Subject: State Significant Development (ssd 8753) - Concrush Teralba
Lake Macquarie City Council reply to Response to Submissions prepared by Umwelt.

Thank you for the opportunity to comment on the Environmental Impact Statement (EIS) for the expansion of the Concrush Resource Recovery Facility, Teralba.

#### DETAIL PLAN

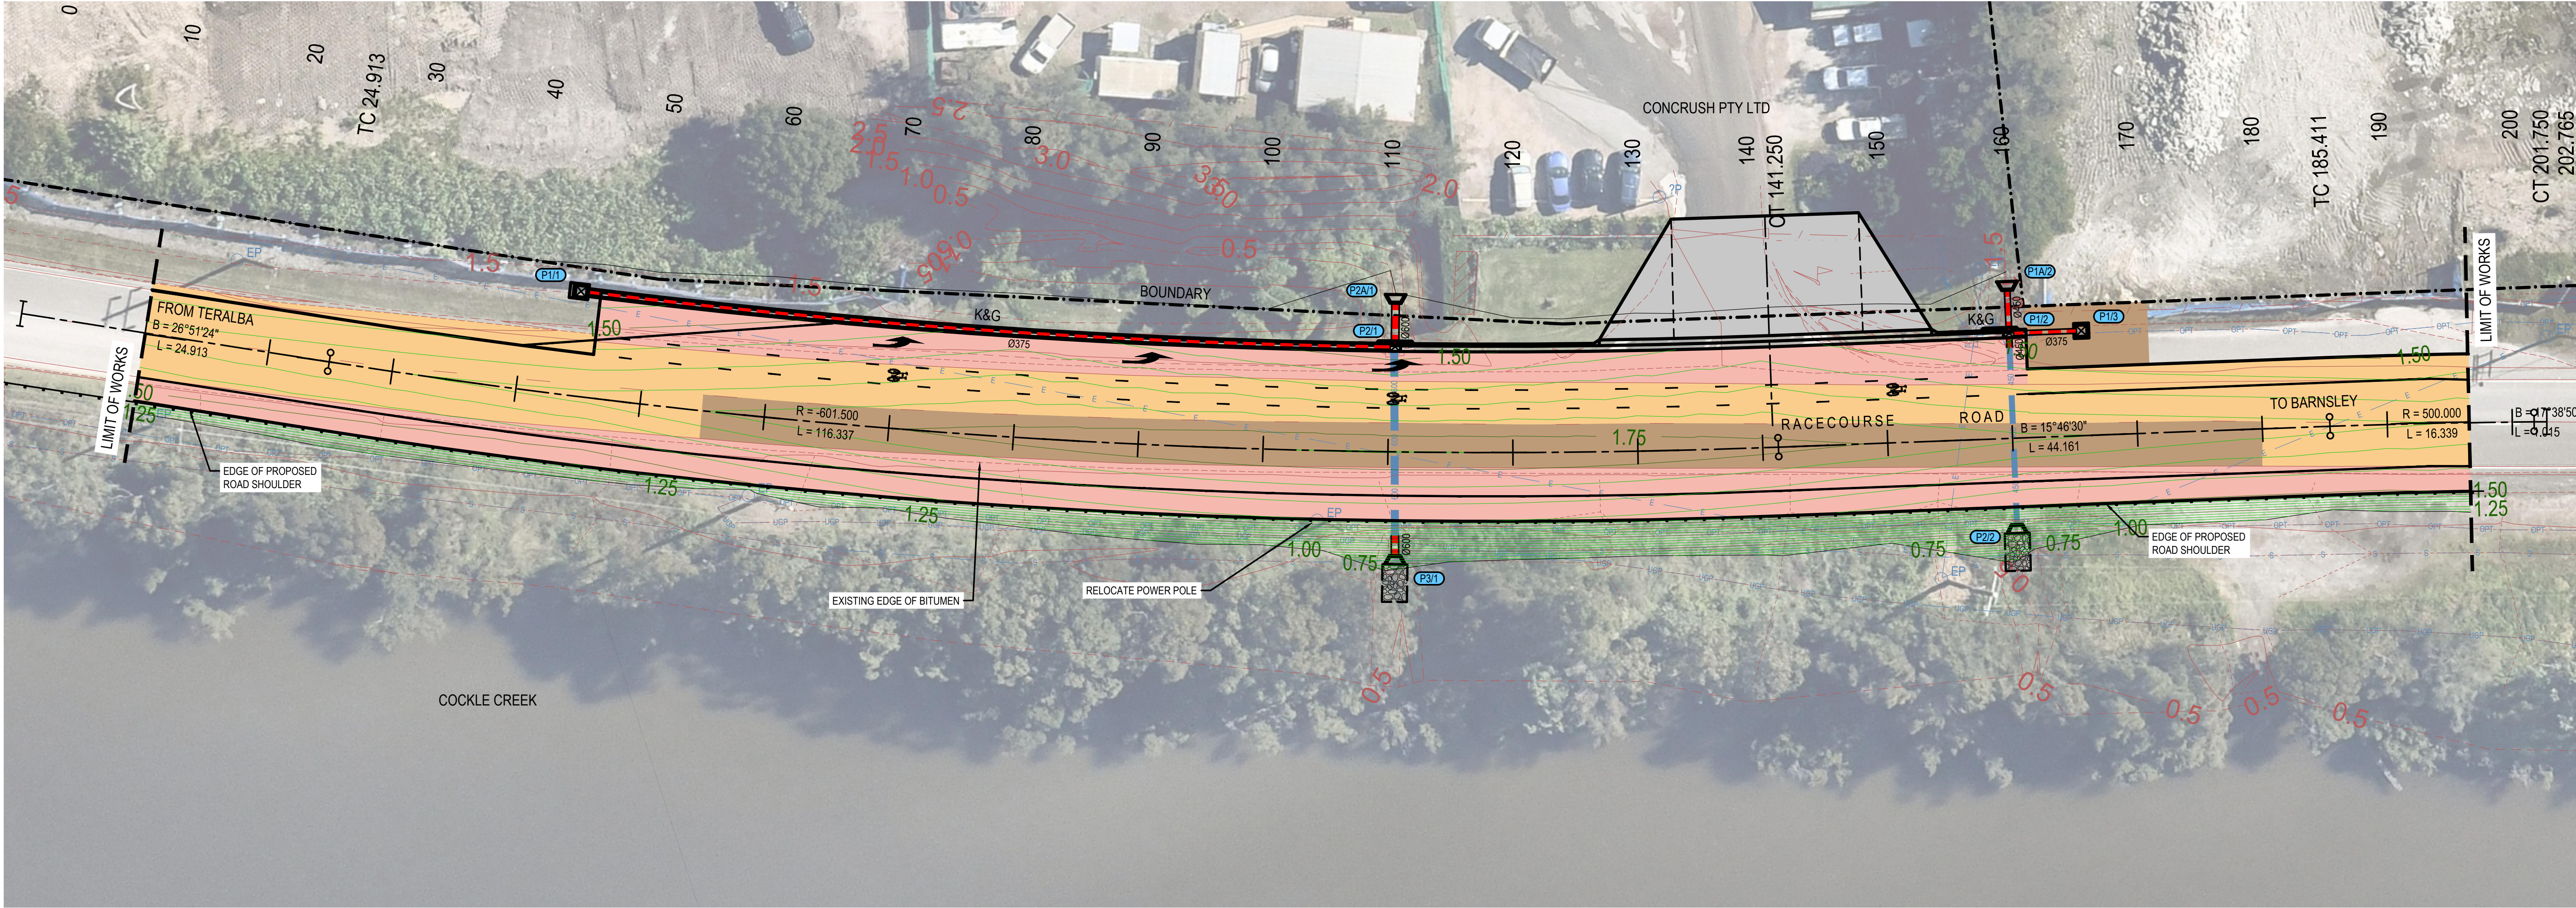
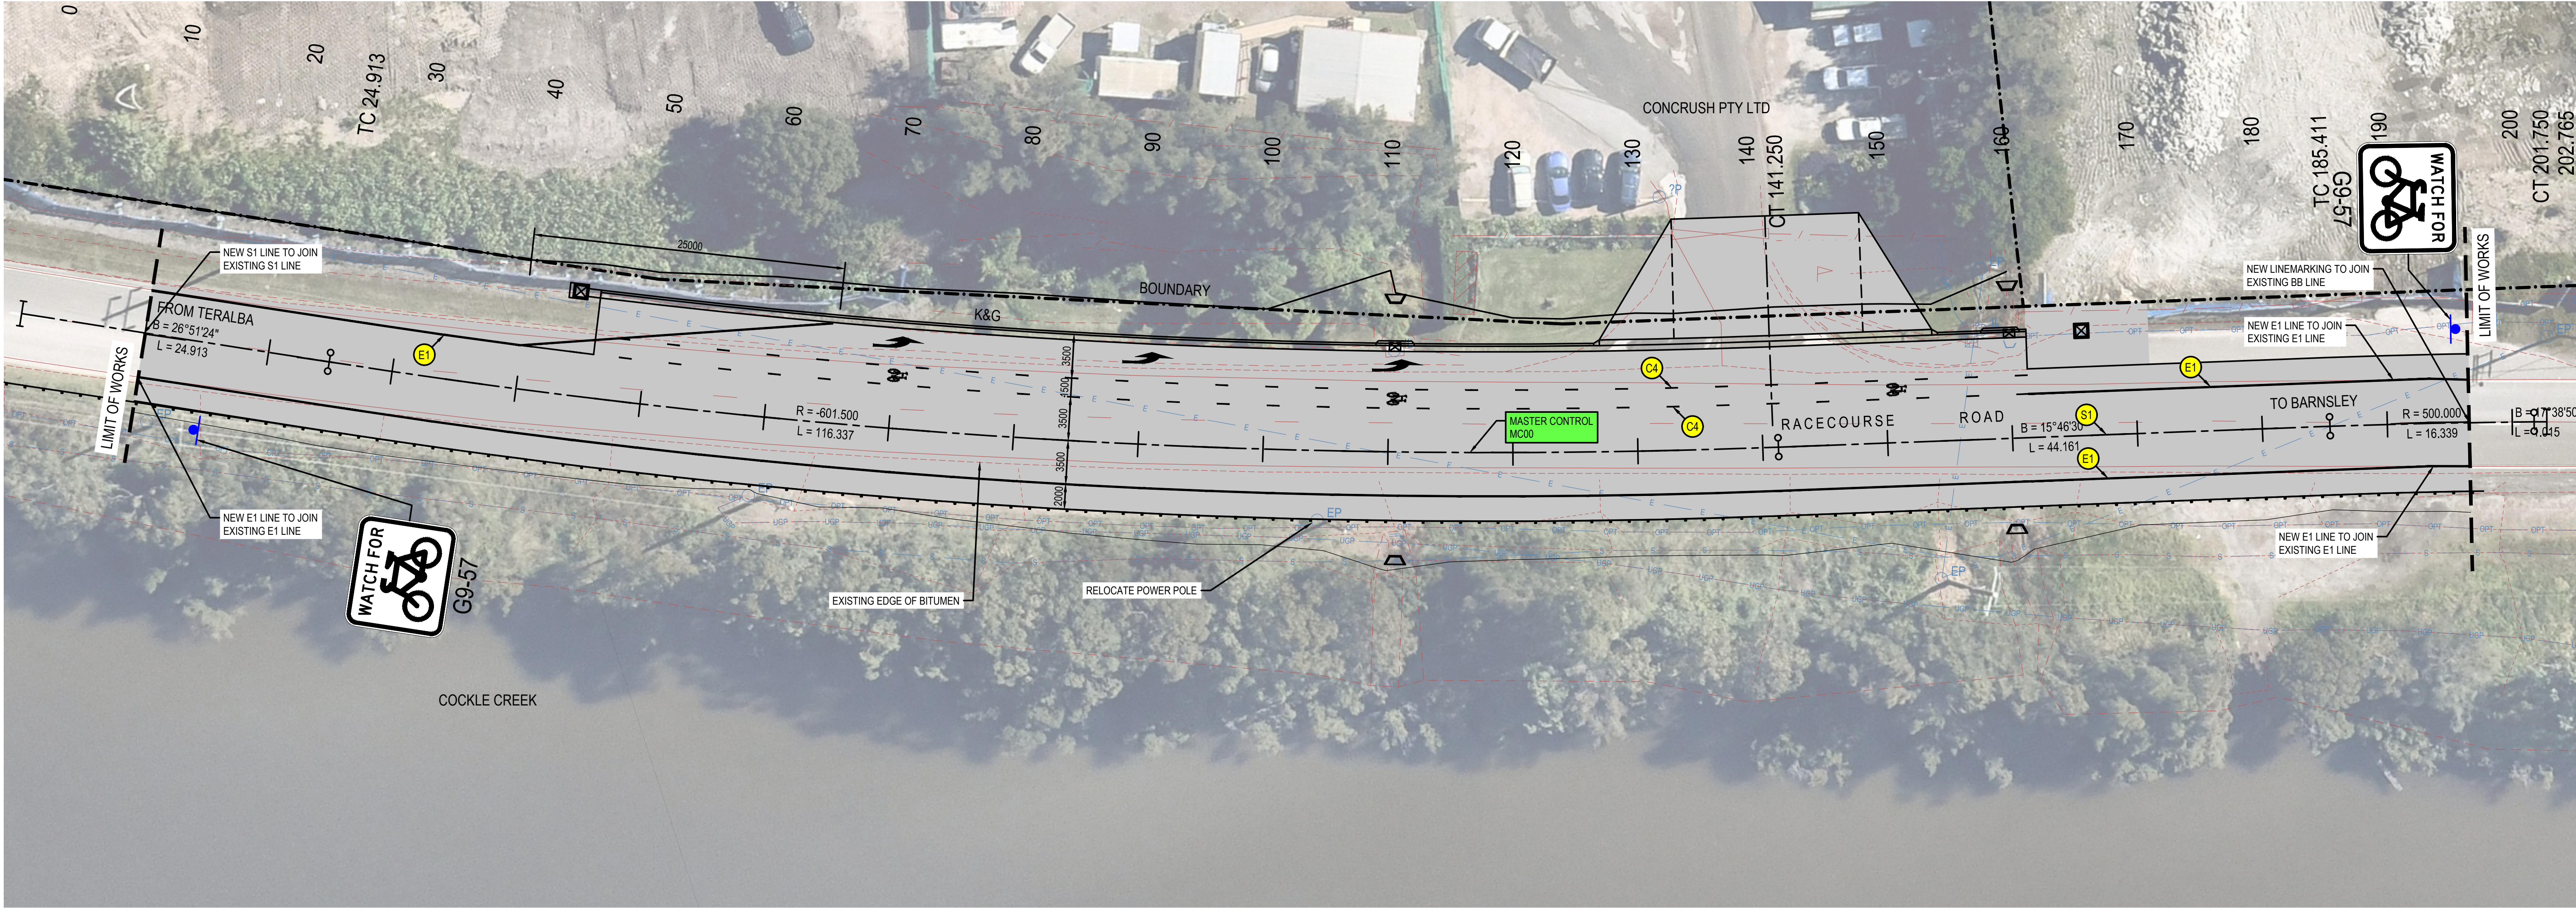
Appendix E of the Response to Submissions document (April 2019), identifies only a BAL turning treatment is required. However the submission appears to use incorrect figures from *Austrroads Guide to Traffic Management Part 6: Intersections, Interchanges and Crossings* (Austrroads 2017). Figure 2.26 (b) graph shall be used to determine the required turning treatments, as the speed limit of the road is 80 kph, rather than Figure 2.26 (c).

By using the correct figure it suggests that a CHR(s) and AUL(s) treatment are required at the entry to the development site. It is also important to note that the vehicles entering the site will likely be heavily loaded and therefore make the turning movement slower than normal passenger vehicles. Racecourse Road also has a high volume of heavy vehicles (approximately 11%) increasing the risk of rear end crashes involving vehicles entering the site. Therefore turning treatments of CHR(s) and AUL(s) are required to be installed as part of the development. These entry treatments are required to be designed to cater for the largest vehicles expected to enter the site.

Cycle lane provision (northbound) and shoulder provision (southbound) is required to transition cyclists safely through the treatments.

Council retains the position that permanent drainage structure such as a concrete v-drain with drainage pits and associated piping or K&G with appropriate drainage should be constructed for the full frontage of the facility. Driveway access is to comply with Council Standard EGSD 202 -2 and be constructed of concrete.

The CHR and AUL treatments and associated signage and linemarking are required to be endorsed by Council's Traffic Facilities and Road Safety Committee (TFC) and approved by Council prior to construction.
